Re: 221734DS1

Project Customer:	GARMAN HOMES	Project Name:	221734DS1
Lot/Block:	78	Subdivision:	SERENITY
Address:	165 RETREAT DR	Model:	WISTERIA B
City:	FUQUAY VARINA	State:	North Carolina

Job 221734FT1	Truss F204	Truss Type Floor	Qty 1	Ply 1	221734FT1 Job Reference (optional)	Paragon ID: 41768 P4430615
------------------	---------------	---------------------	----------	----------	---------------------------------------	-------------------------------

Job Q2200860	Truss F204	Truss Type Floor	Qty 7	Ply 1	Garman Homes - Wisteria A & B Job Reference (optional)
-----------------	---------------	---------------------	----------	----------	---

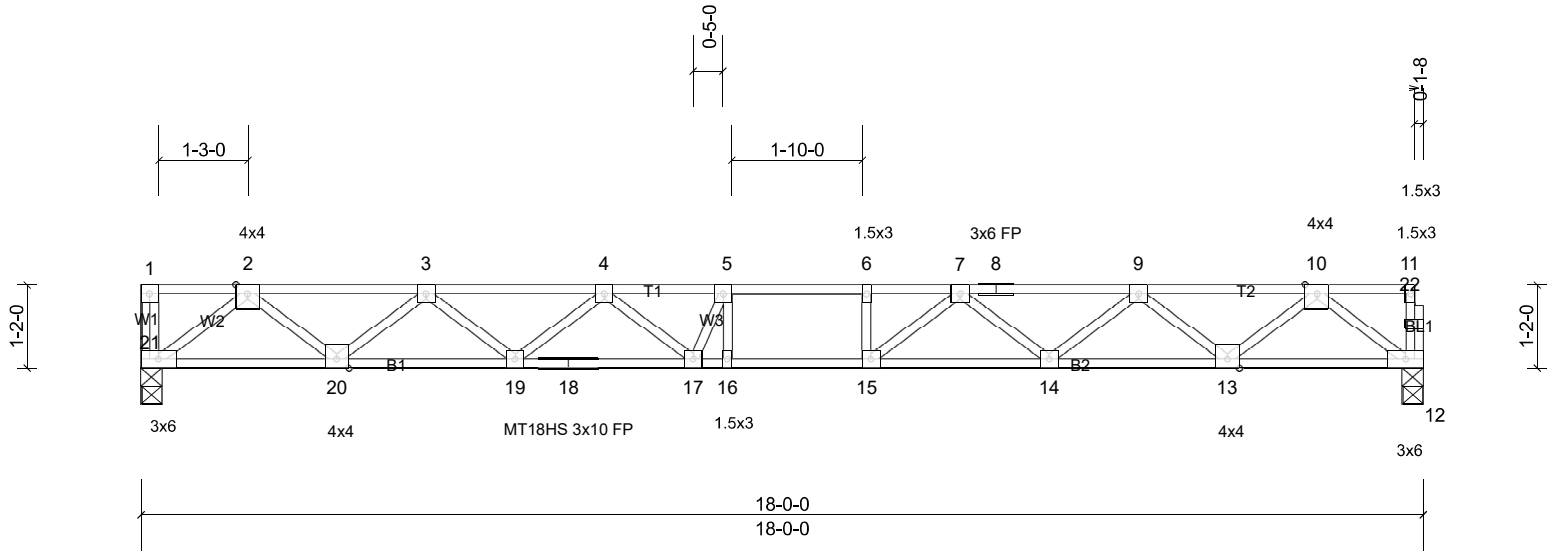
**1) EXTEND 3" OF THE TRUSS AT EACH END AS SHOWN. BEARING RELOCATED.**

(A) ADD (4) NEW 4 x 2" SP No.2 MEMBER(S) AS SHOWN - CUT TO FIT TIGHT. ATTACH ONE MEMBER TO EACH END VERTICAL WITH ONE ROW OF 10d (3" X 0.131") NAILS SPACED 4" OC. FASTEN NEW MEMBERS TOGETHER WITH 10d (3" X 0.131) NAILS SPACED AT 4" OC. STAGGER NAILS FROM FIRST MEMBER TO SECOND MEMBER FOR A NET 2" OC.

(B) APPLY 23/32" 48/24 OR 24 OC SPAN RATED OSB GUSSETS TO EACH SIDE OF TRUSS AS SHOWN. ATTACH EACH GUSSET WITH (1) ROW OF 10d (3" X .131") NAILS SPACED @ 4" OC INTO ALL MEMBERS. STAGGER SPACING FROM FRONT SIDE TO BACK SIDE FOR A NET 2" OC SPACING IN THE TRUSS MEMBER.
